**Re: Lot 26-A, Block J, Lavaland Addition
Grading and Drainage Plan for Building Permit**

**File: K-11/D082
PE Stamp 08-04-2013**

Re: **Lot 26-A, Block J, Lavaland Addition (K-11/D082)**
Grading and Drainage Plan for Building Permit
Engineer's Stamp dated **06-20-2013**

Based upon the information provided in your submittal dated 6/20/13, the above referenced Grading and Drainage Plan cannot be approved until the following comments are addressed:

DRAWING:	DRAWN BY:	DATE:	SHEET #
201314-GR.DWG	SH-B	05-29-2013	1

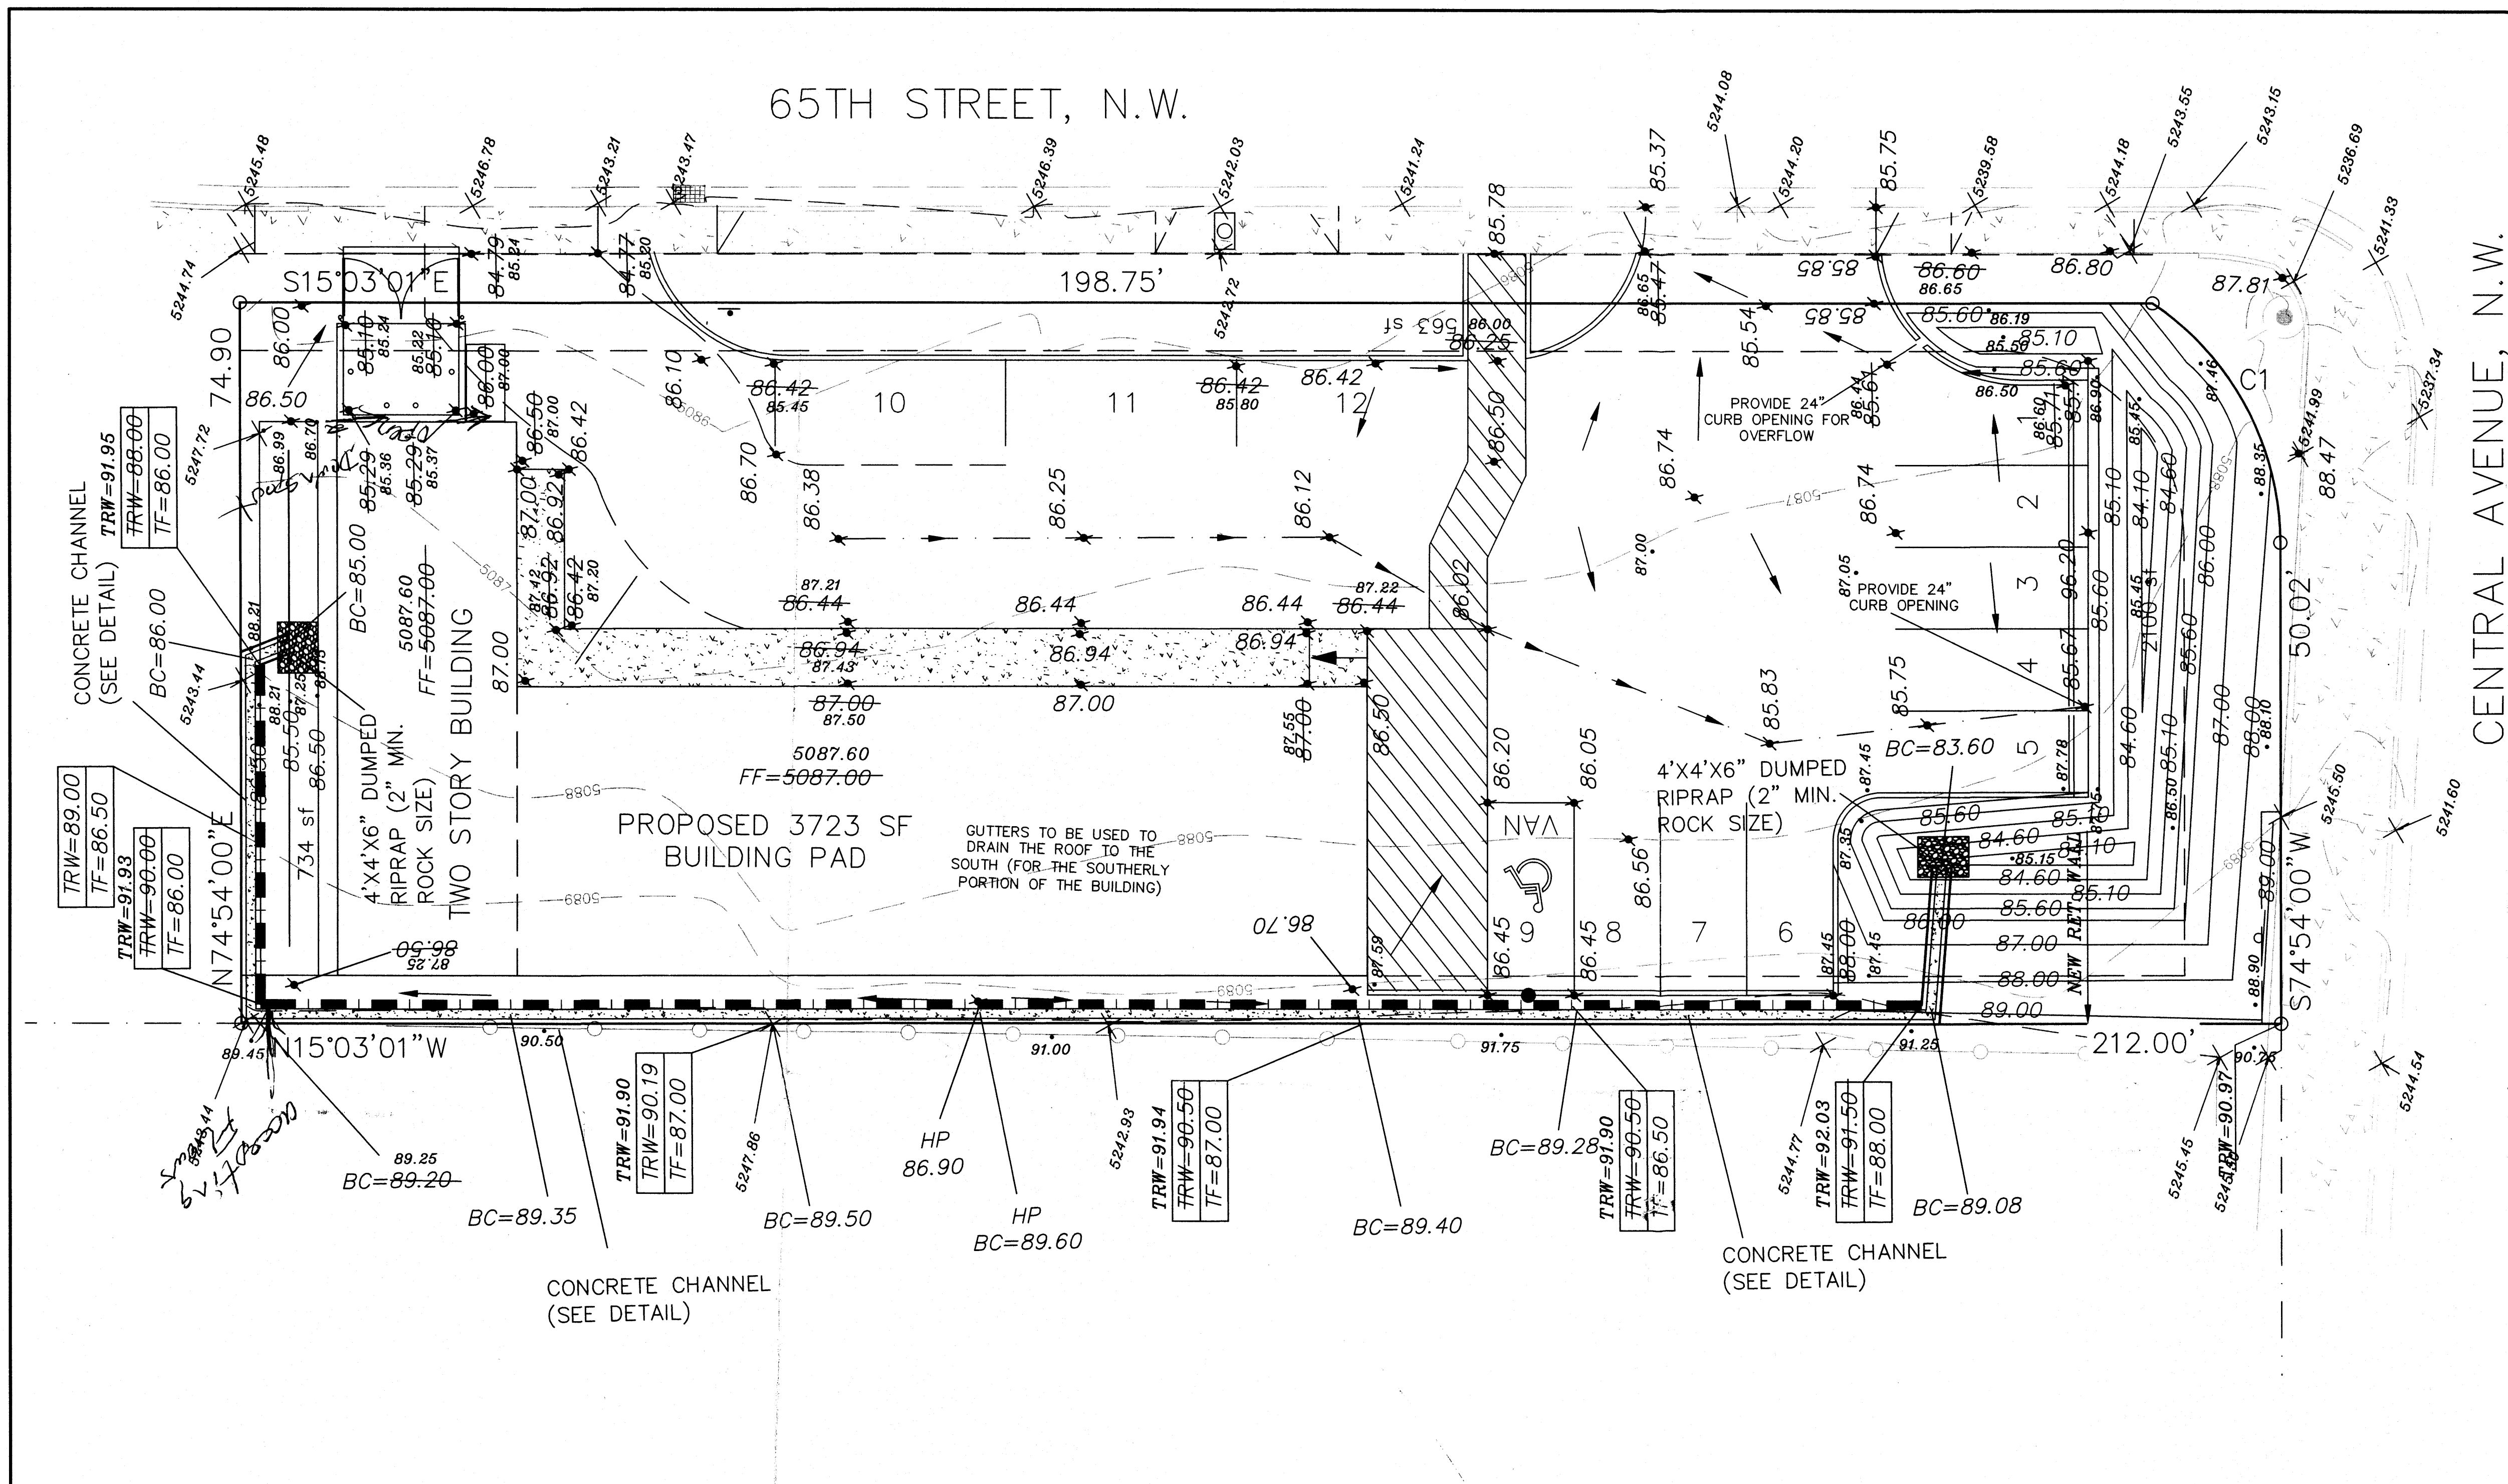
Please attach a copy of this approved plan to the construction sets when submitting for a Building Permit. I acknowledge the handwritten note on this plan, near the NE corner of the site, which clarifies that the entrance curb will be aligned per the site plan. Please show the as-built configuration on your Grading Certification Plan.

- Provide additional spot elevations along the back-of-sidewalk just north of the proposed detention pond.
- Include drainage calculations for the two 12" curb openings. Hydrology suggests that they be widened to 24" to accommodate drainage flows from the pond.
- Show the water surface elevation on the grading plan.
- Correct the legend to reflect the displayed hash lines for the existing retaining wall.
- A site visit identified significant offsite flows from the parcels west and northwest of the site. Determine and show the extent and quantity of offsite flows and provide design details for conveying those flows through this site.
- Correct the "Existing Drainage Conditions" of the narrative to reflect the presence of an existing garden wall to the north of the site. No runoff is received at this location but significant runoff does enter the site from the existing car lot to the west.
